Valentin Residence

ADDRESS ESA
RECOMMENDATIONS
TO CRITICAL AREAS
REPORT
June 8th, 2018

File No. CAO17-003 – Valentin Critical Areas
Determination

4346 E Mercer Way, Mercer Island, WA 98040

Figure 5: 20 foot wide buffer and five foot setback for potential future daylighting

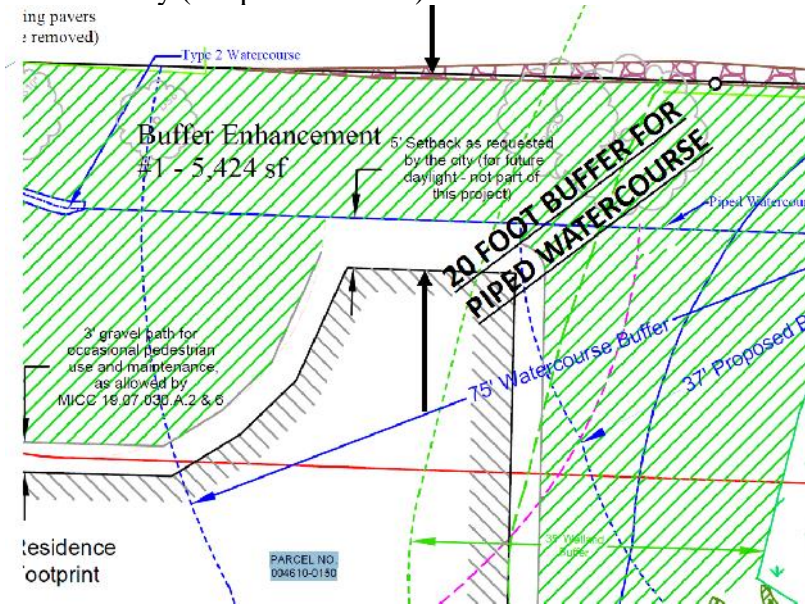
ESA Recommendation #3: The 5-foot buffer proposed for the piped portion of the stream adjacent to the eastern side of the residence could inhibit *future daylighting* of the stream due to its narrowness. A minimum 10-foot buffer shall be provided.

Response: The applicants Biologist has analyzed the terrain and positively concluded that the 20 foot buffer and five foot setback provided will not inhibit future daylighting. The Biologist has analyzed the grade, depth and overall size of the area in question. Please see details below and in the revised report.

Future daylighting, although encouraged, is not a code requirement or criterion for approval for an 18 foot stretch of piped watercourse.

- The piped watercourse will be in a 20 foot wide area between the building envelope and the northern property line (The City's planning director had originally proposed placing the stream in a 10 foot area which would have allowed for only a maximum of five feet on each side).
- The five foot setback/distance from the piped watercourse to the building envelope is limited to 18 feet (see picture on previous slide).
- The slope is 1" per foot, and so the area in question is relatively flat (see picture on previous slide).
- The depth of the pipe is less than three inches (see picture on previous slide).
- Future daylighting, although encouraged, is not a code requirement or criterion for approval for an 18 foot stretch of piped watercourse

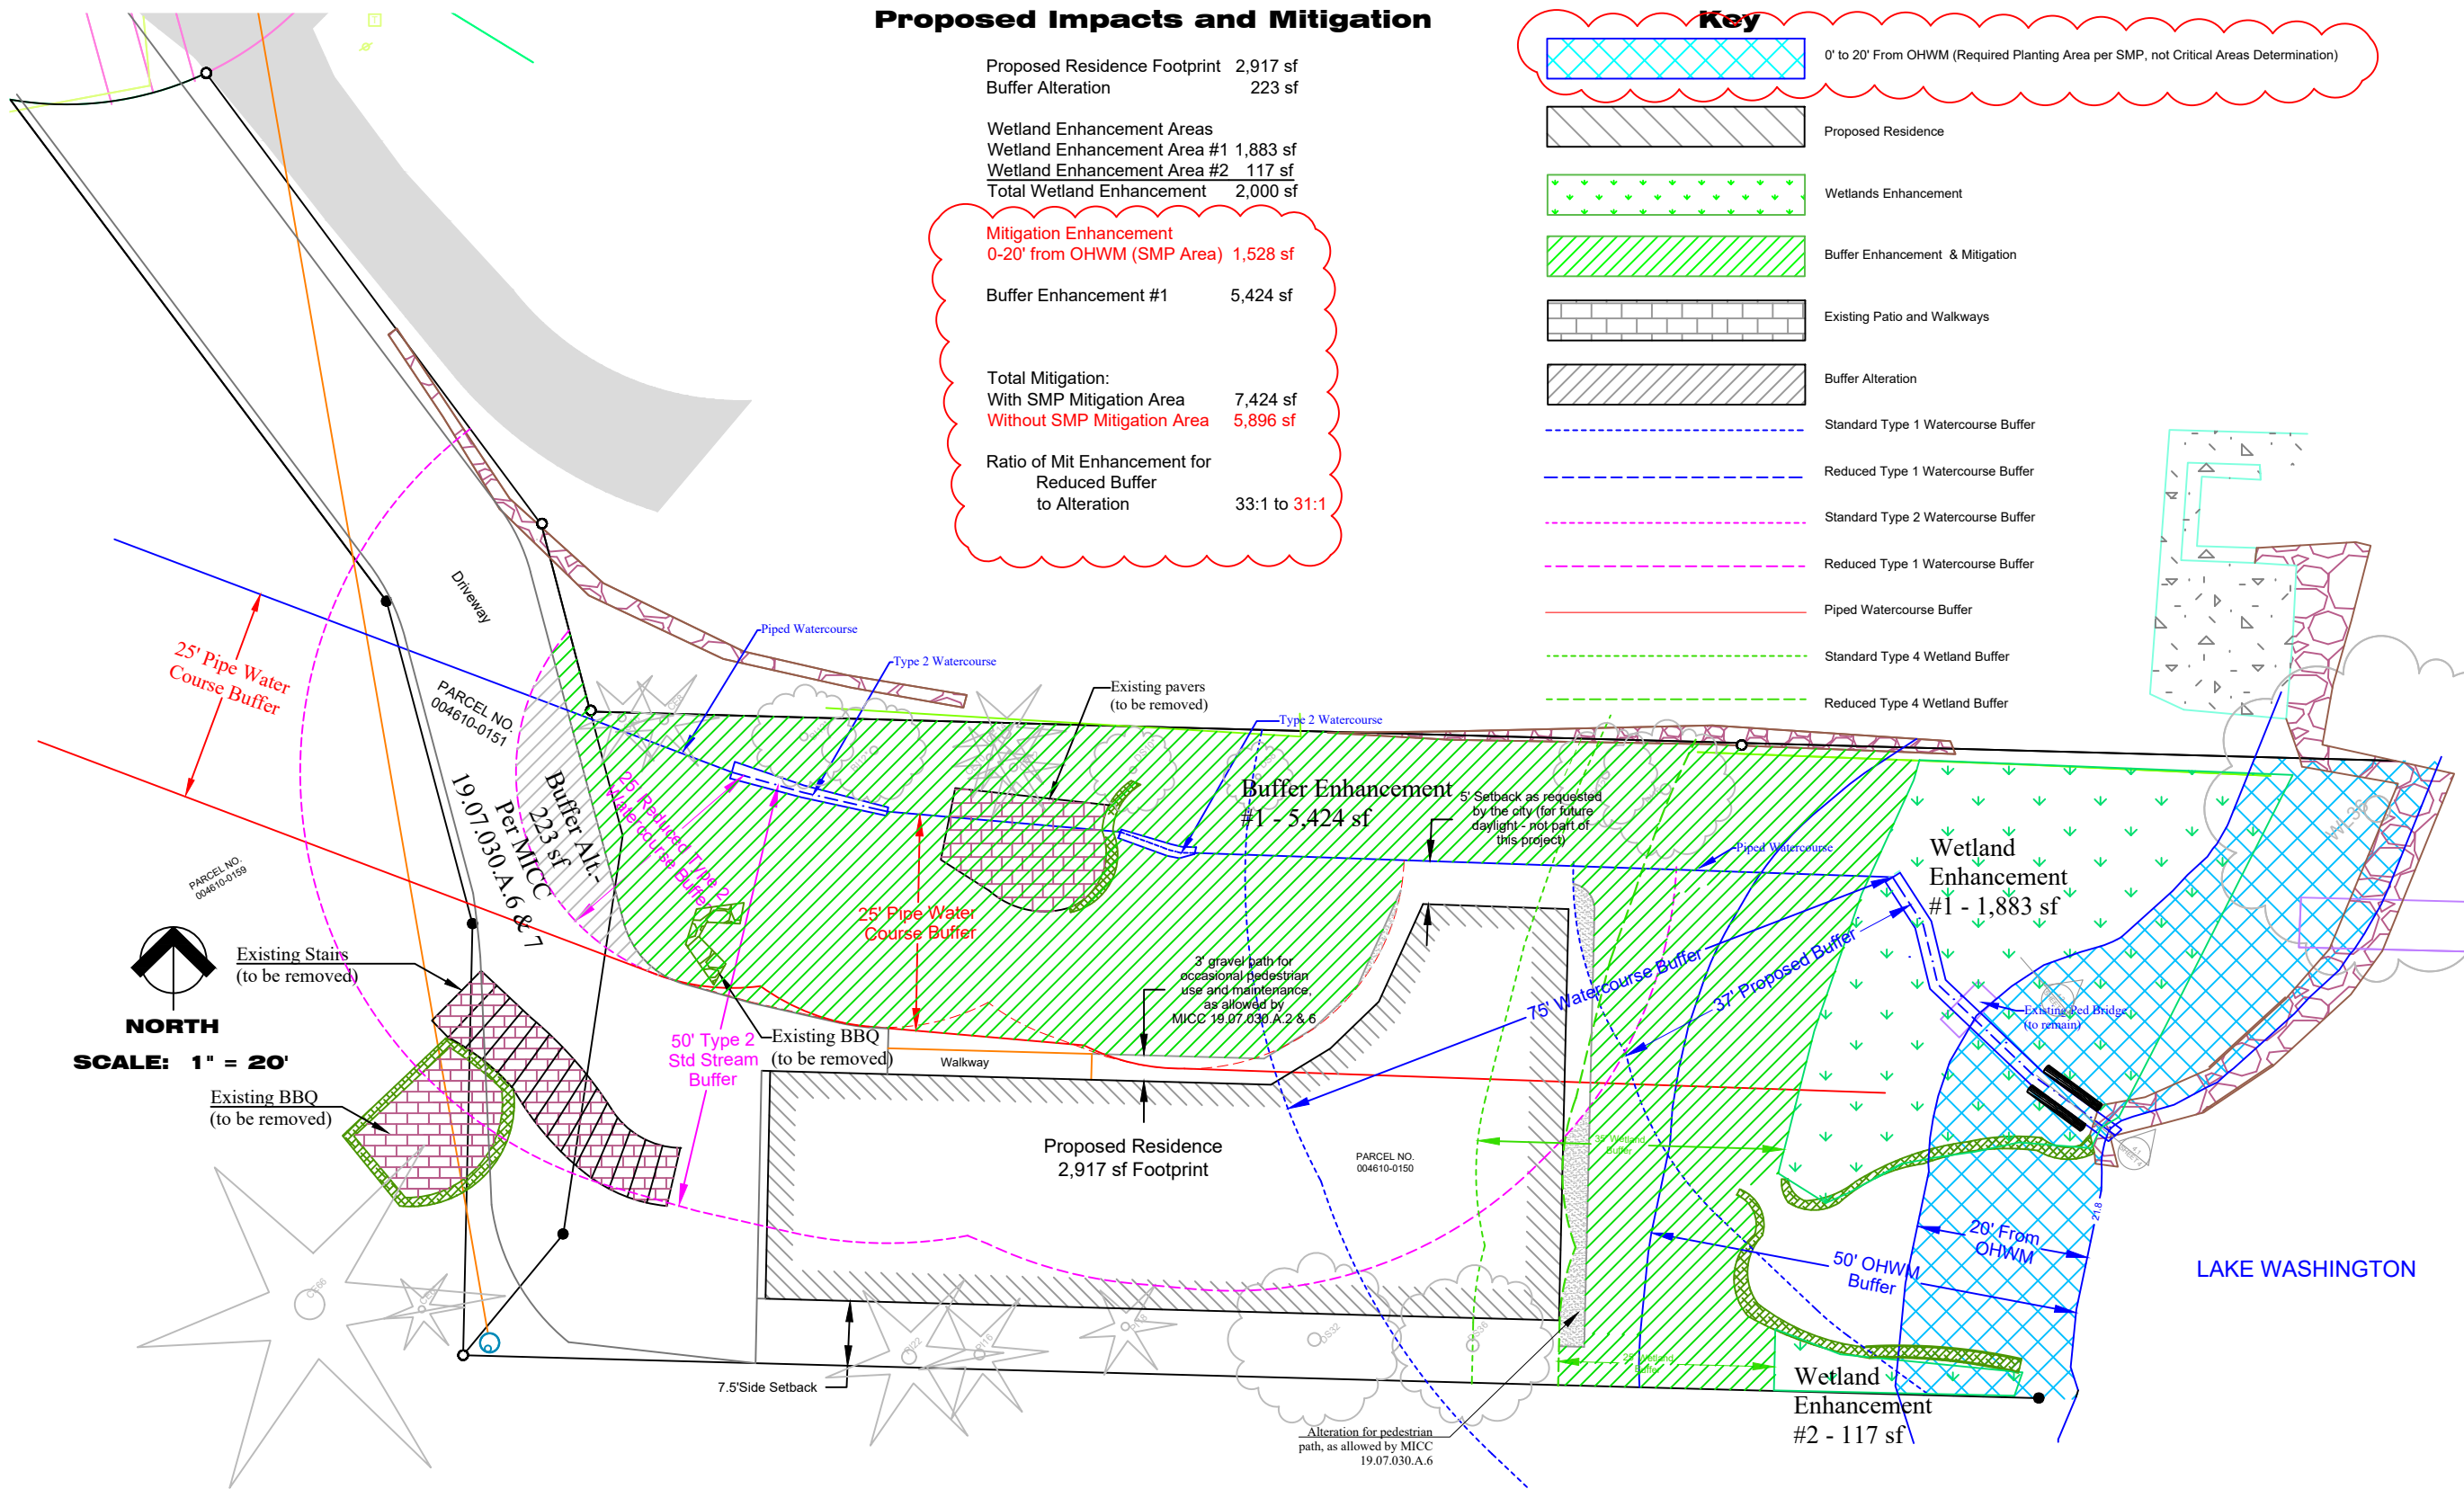
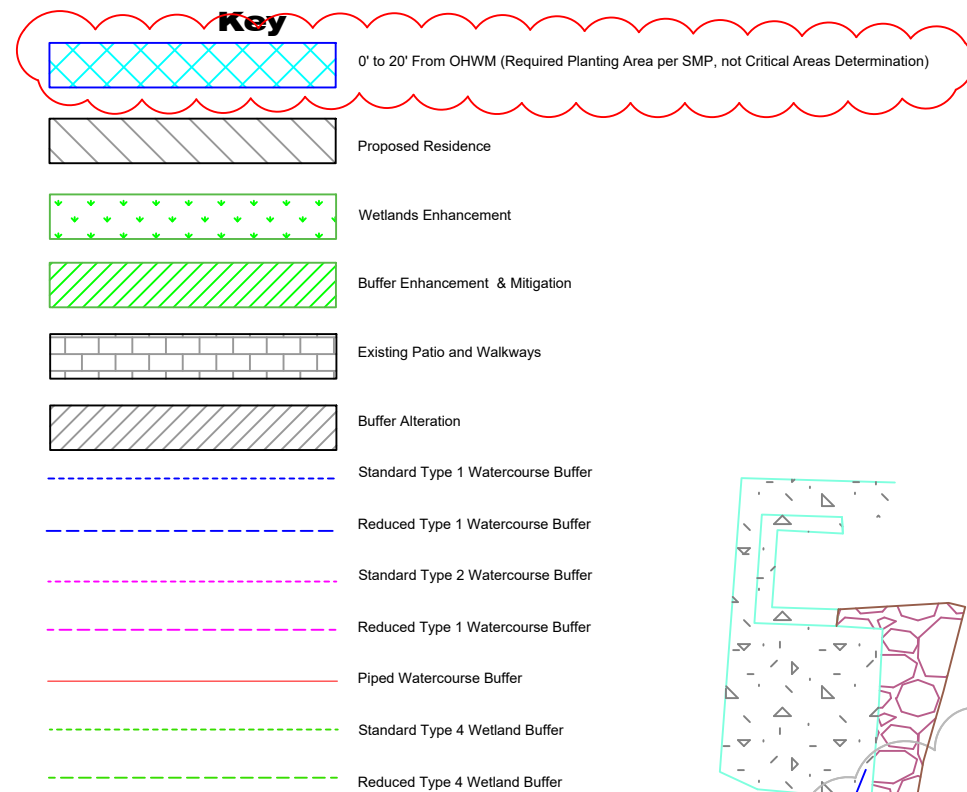
ESA Recommendation #1: The shoreline management requirements are separate from the wetland and stream buffer reduction requirements so the area within 20 feet of the Ordinary High Water Mark should not be included in the wetland and stream buffer calculations consistent with MICC 19.07.110(9)(d)(i). These areas shall be removed from the mitigation ratio calculations for buffer reduction.

The 20' SMP area now has a unique key to distinguish from the buffer enhancement. The calculations list SMP area separate from buffer enhancement.

DETAIL 4.1 WATERCOURSE REGRADING (ELEVATION VIEW)

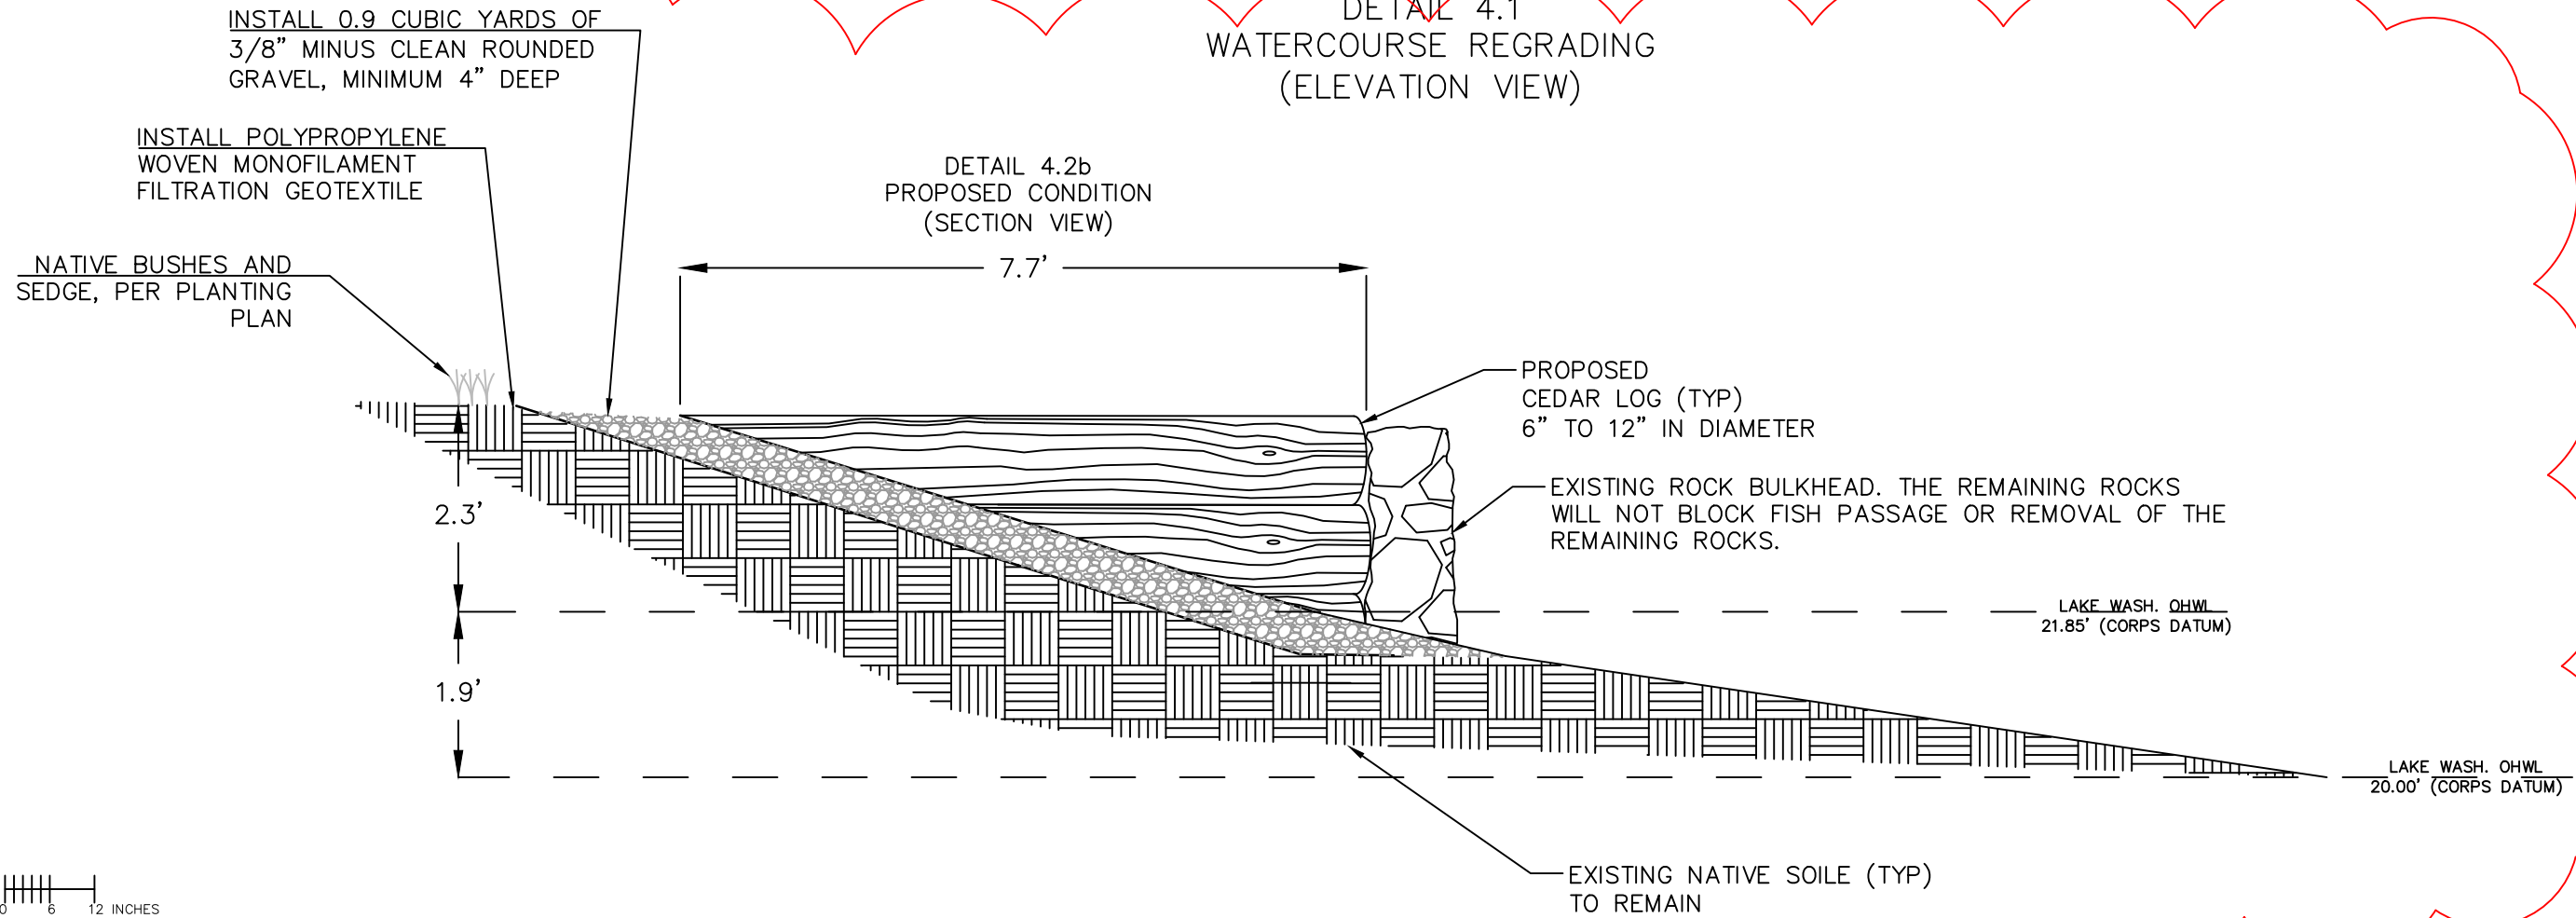
Please provide additional detailed information for the proposed fish blockage removal. Provide the total area of excavation and grading within the stream, the proposed construction sequencing, the engineering design versus conceptual plan, and a statement that the remaining rocks in the stream channel will not block fish passage or removal of the remaining rocks.

- a. The total area of excavation and grading of the watercourse has been added to Sheet 4 of 5.
- b. The details of construction sequencing has been added to Sheet 4 of 5.
- c. More detailed design has been added to sheet 4 of 5.
- d. The following statement has been added to Sheet 4 of 5:

The remaining rocks in the stream channel will not block fish passage, nor will removal of the remaining rocks.
